**RE: McDonalds – Coors and Hanover
1501 Coors Blvd NW
Grading Plan Engineer's Stamp Date: 2/28/17
Hydrology File: J11D037**

Based upon the information provided in your submittal received 3/9/17, the Grading Plan is approved for Building Permit, Grading Permit, and Paving Permit.

RE: McDonald's 1501 Coors Blvd.
File # J11-D037

POND PROFILES & CALCULATIONS

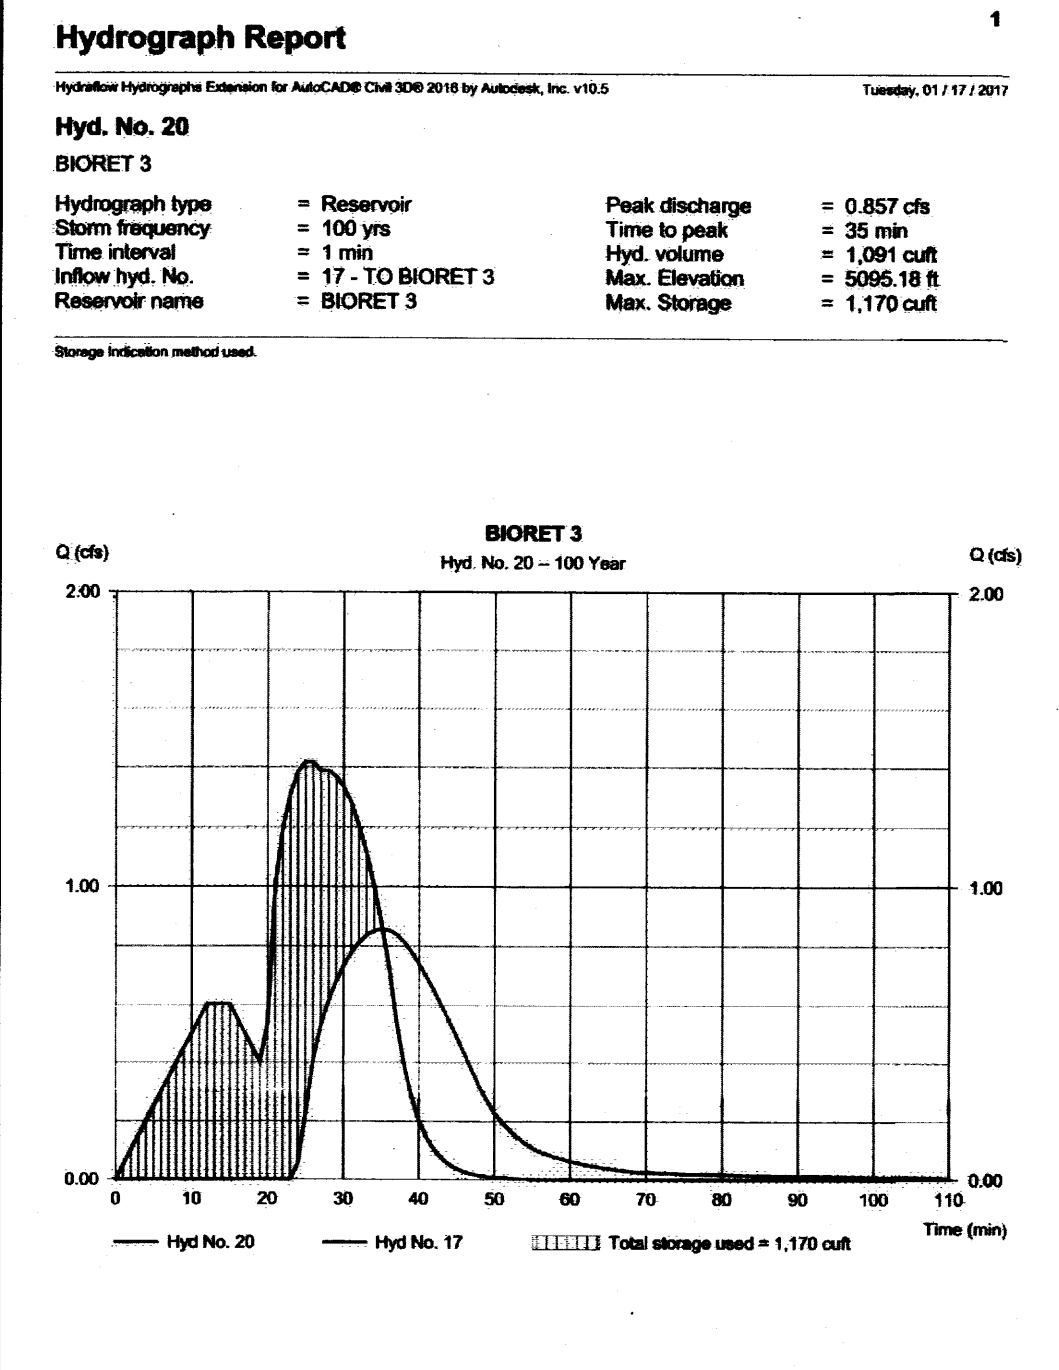
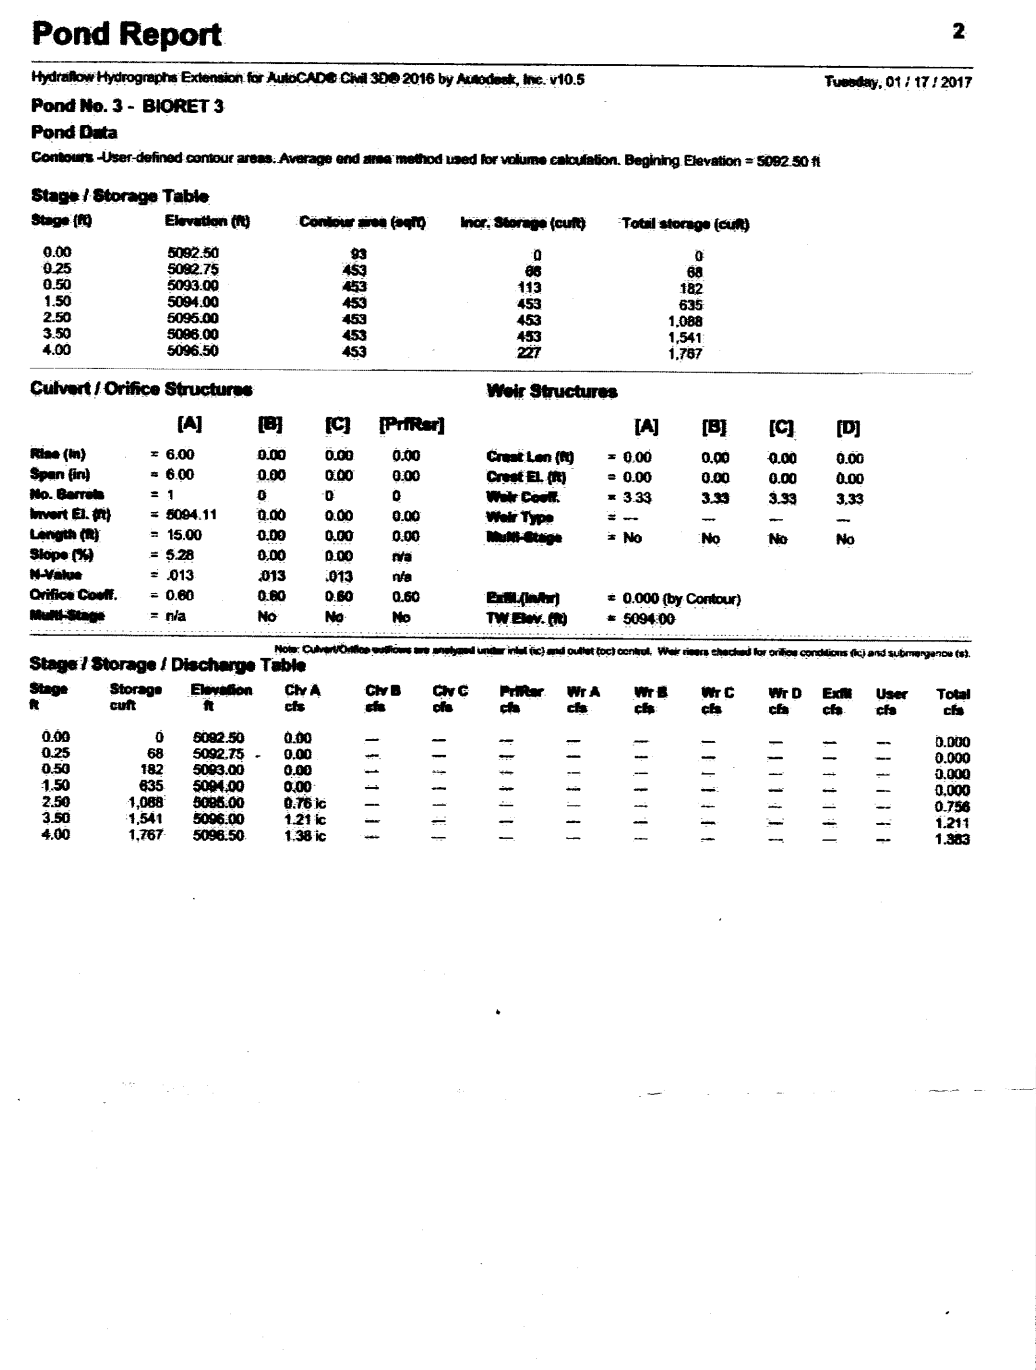
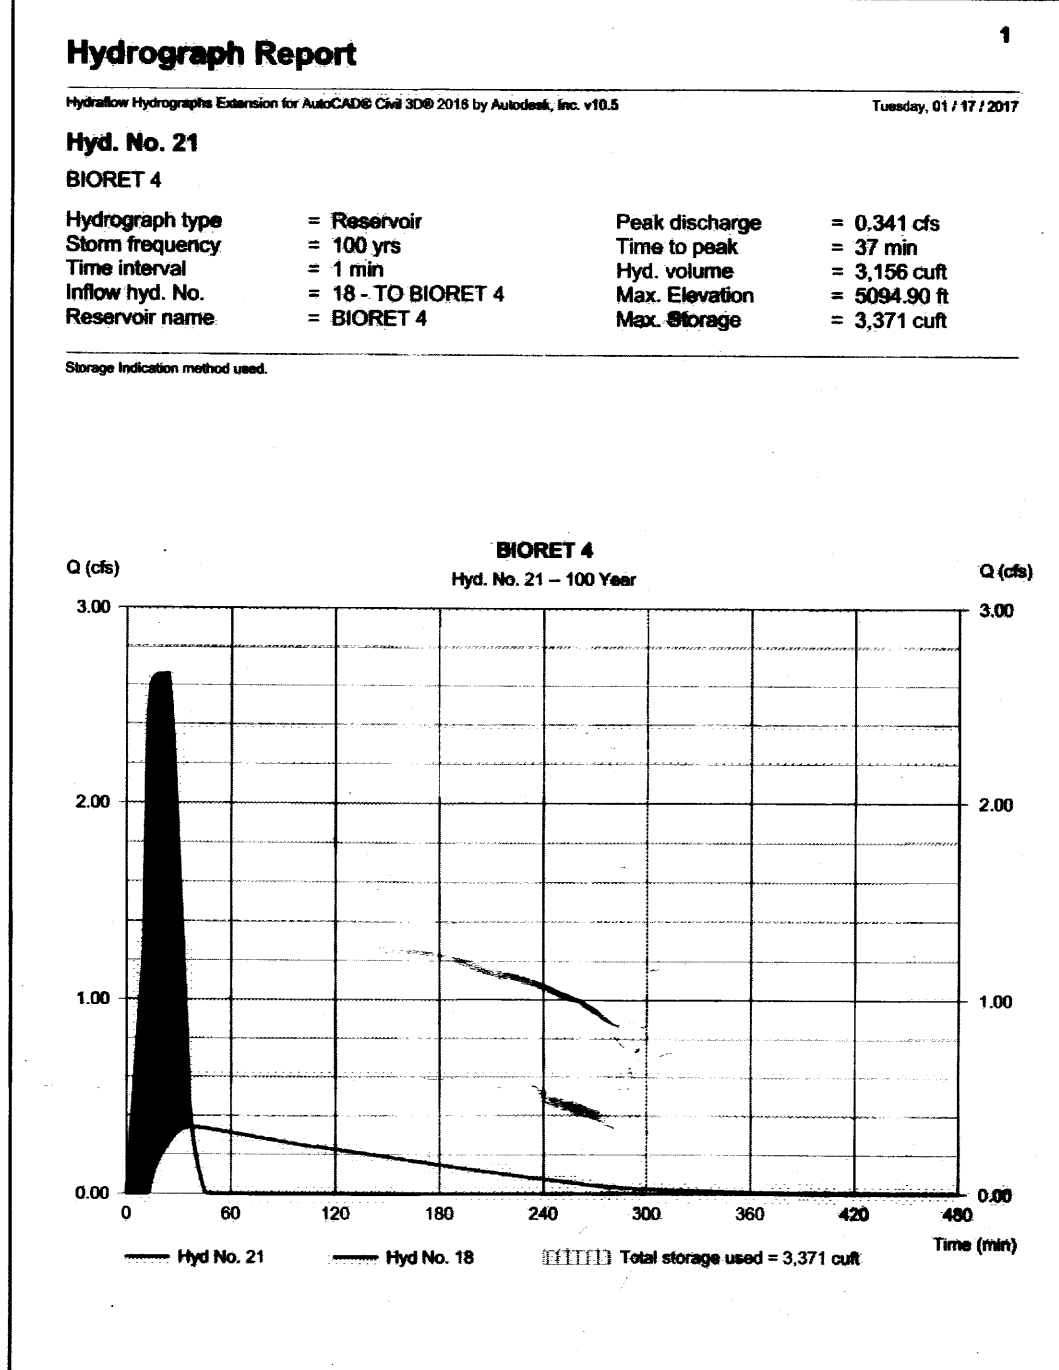
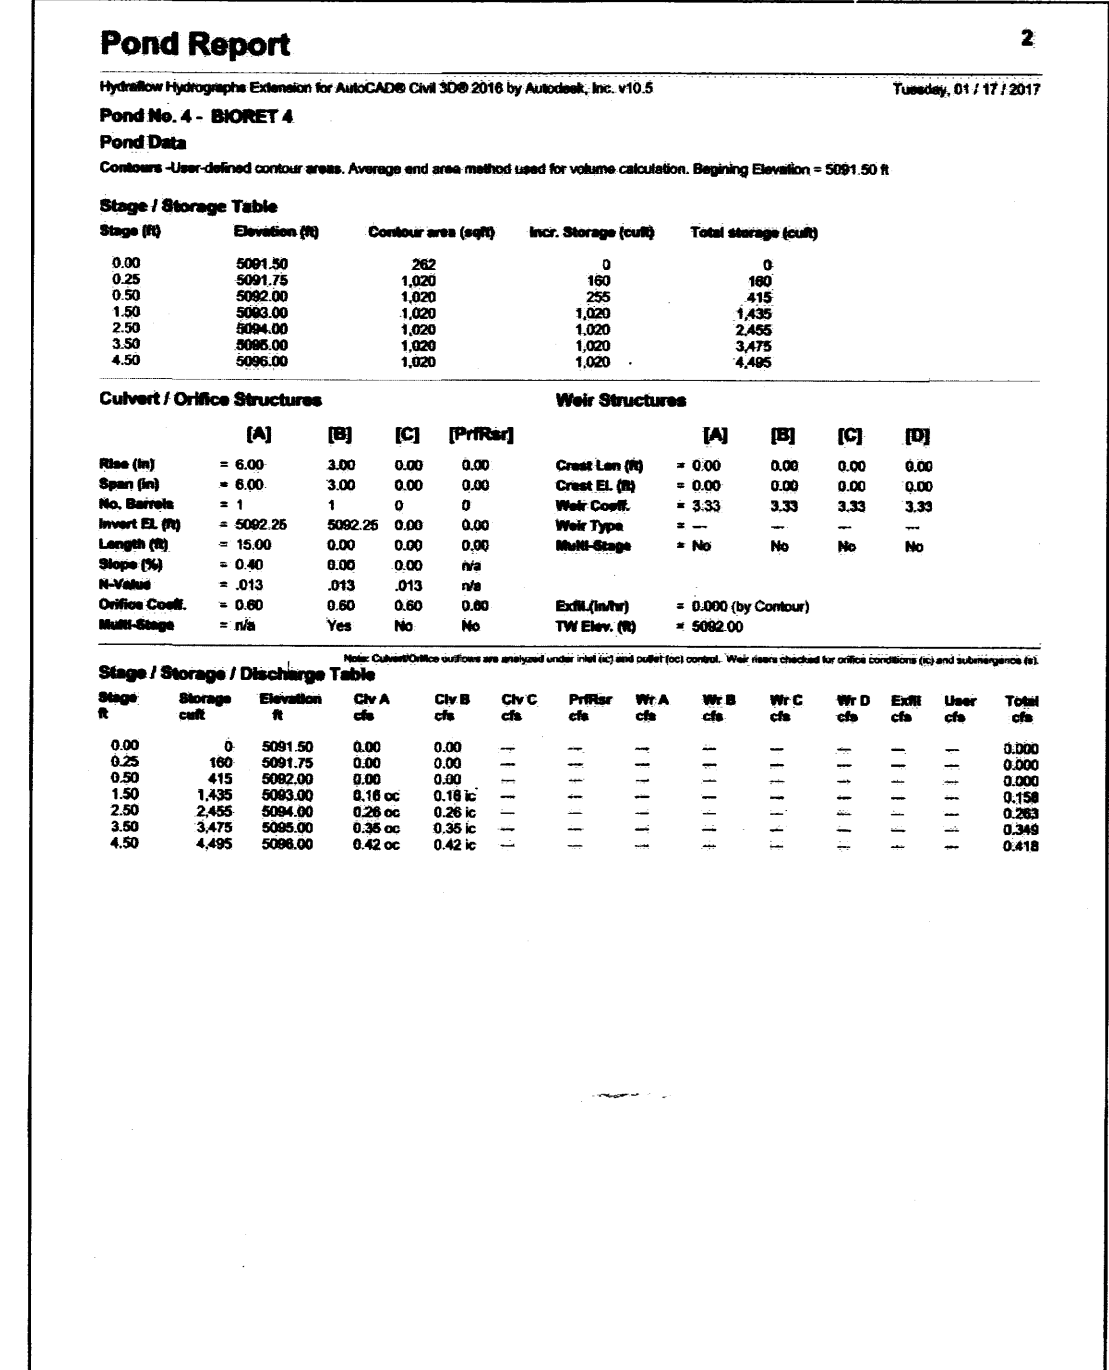
- ✓ • We have added a note for MH#4 to be lowered to match proposed top of pavement.
- ✓ 4. Ensure the fence around Bio-retention Areas 3 and 4 is at least 42" in height.

- The fence around Bio-retention Areas 3 and 4 will be 4' tall. The detail is shown on Sheet C10.4 Standard Details.
5. Waterblocks, at least 8" high from top of pavement on the drivepad to bottom of gutter along the road, need to be incorporated at the Coors entrance. Correspondence is attached.
